Appeal Decision

Appeal Ref: APP/R5510/D/22/3311275

322 Balmoral Drive, Hayes, Hillingdon UB4 8DJ

- The appeal is made under section 78 of the Town and Country Planning Act 1990 against a refusal to grant planning permission.
- The appeal is made by Mr N Ahmed against the decision of the Council of the London Borough of Hillingdon.
- The application Ref 32141/APP/2022/2708, dated 30 August 2022, was refused by notice dated 25 October 2022.
- The development proposed is conversion of garage into a habitable room, ground floor rear extension, and first floor side extension.

Drawing name:
Proposed Plans

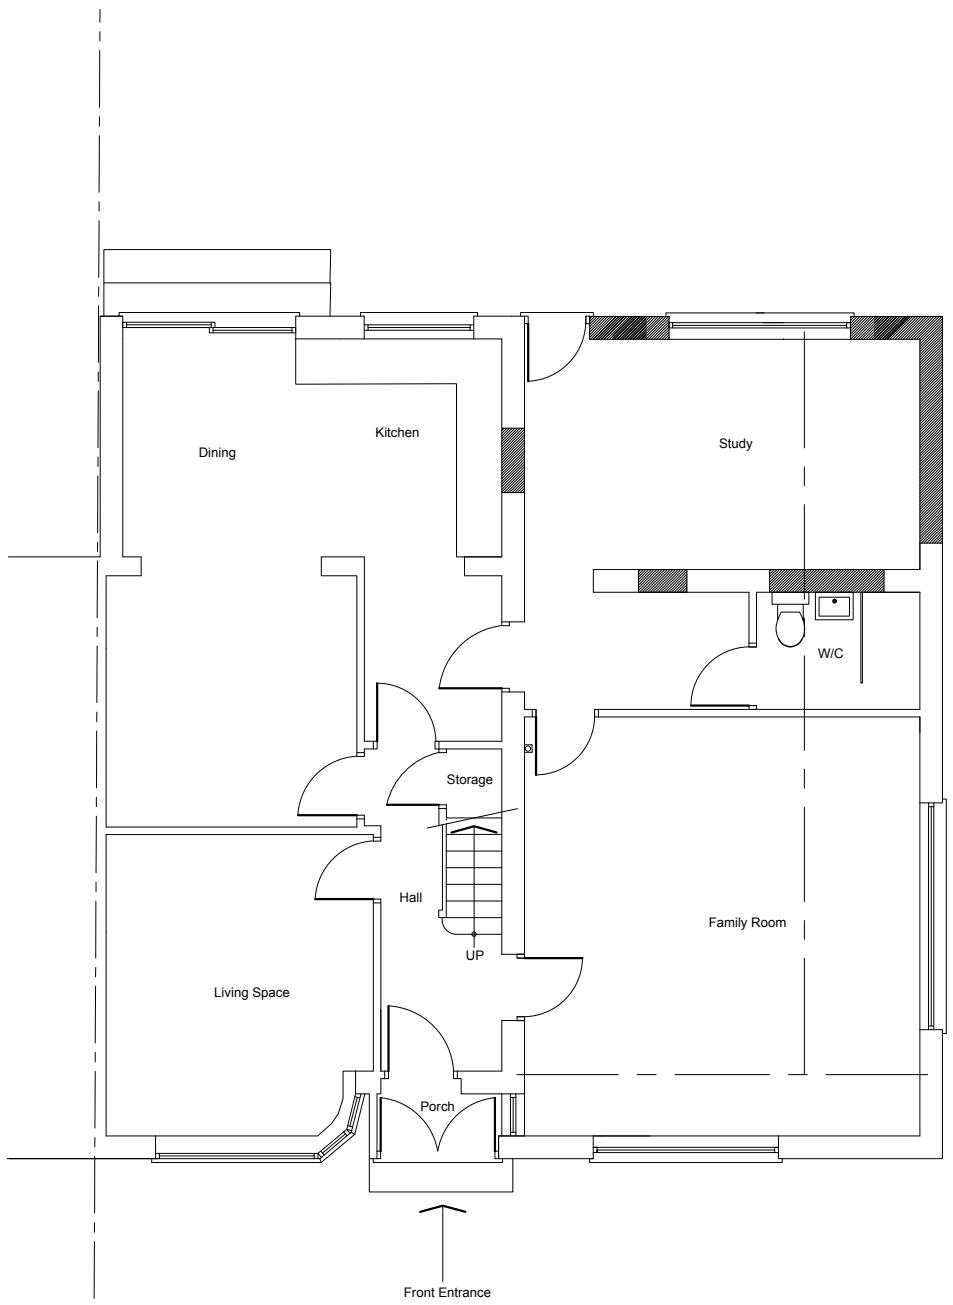
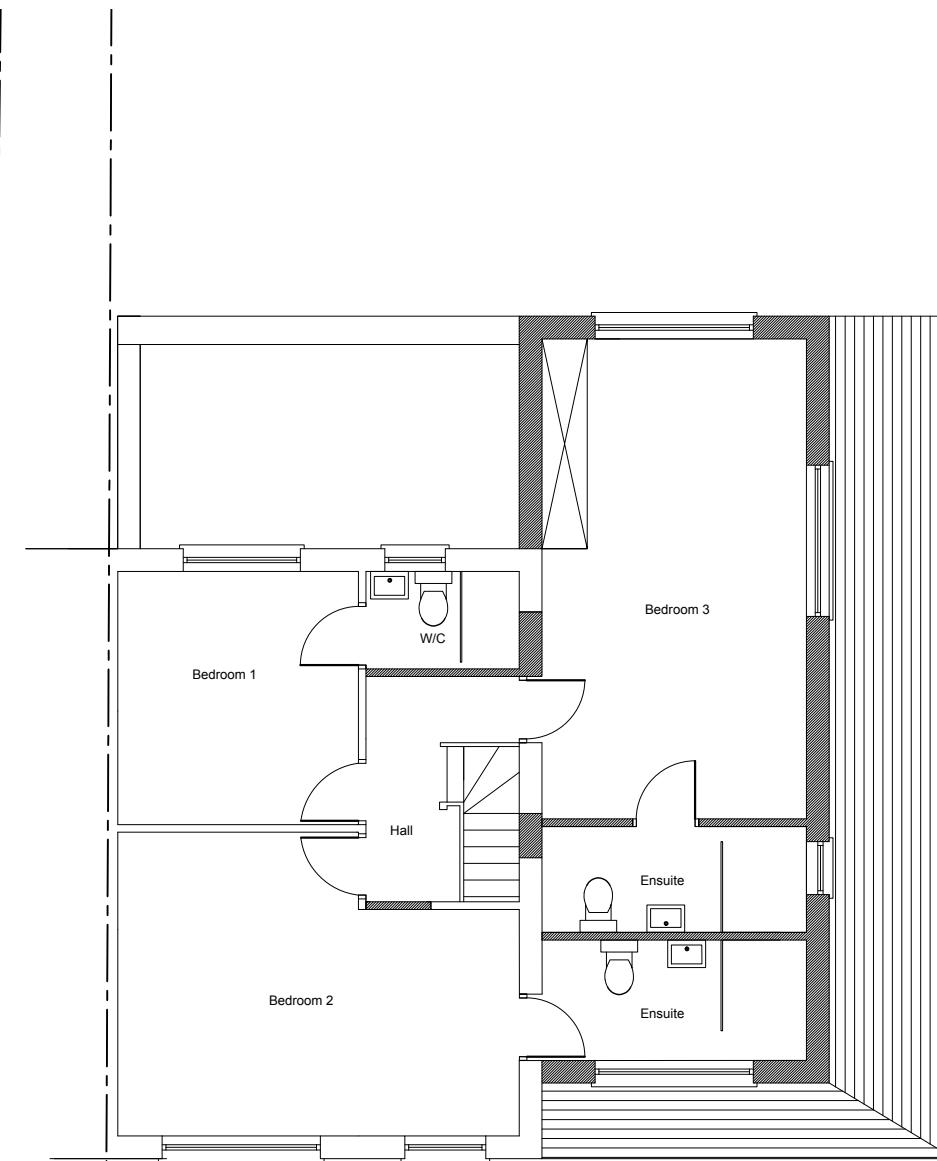
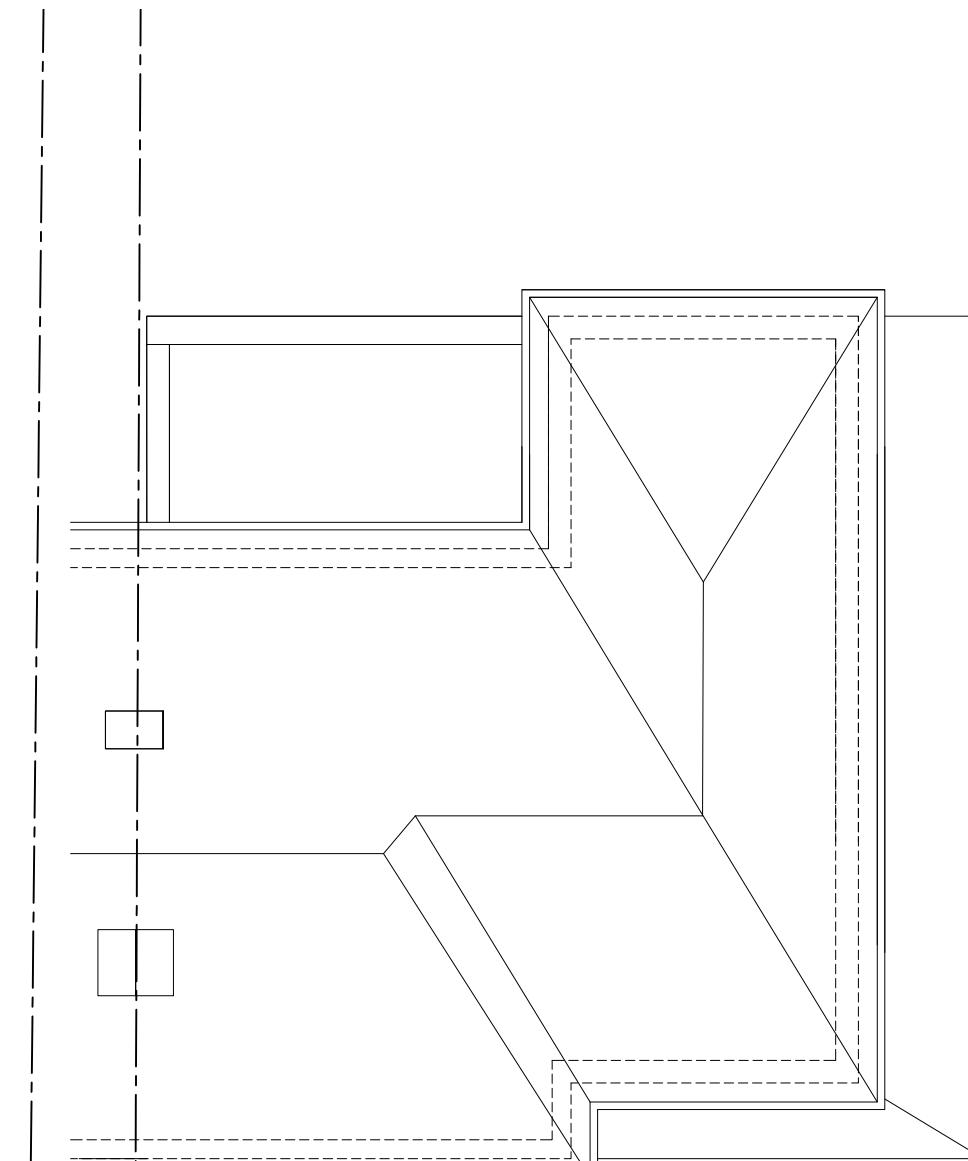
5. The proposal includes extensions above and to the rear of the existing garage. The first floor element would be narrower in width than the ground floor and would be set back from the front elevation with a corresponding lower ridge height. This would give some impression of subservience to the host building when viewed directly from the front.

6. However, it would still be an extension of significant size in relation to the original building. This would be particularly evident when viewed from the side where the length and height of the flank elevation would have considerable

bulk and massing in close proximity to the side boundary, notwithstanding the stepped-in design. The result would be an unduly dominant addition that fails to respect the form and proportions of the host building. Furthermore, whilst I do not share the Council's concerns in relation to the effect on the return building lines along Mansfield Drive, the height and bulk of the extensions would result in a street scene that is materially more enclosed at this corner junction, to the detriment of the spatial quality of the area. The overall effect would be a design and scale of development that does not integrate sensitively with the host building and its immediate surroundings.
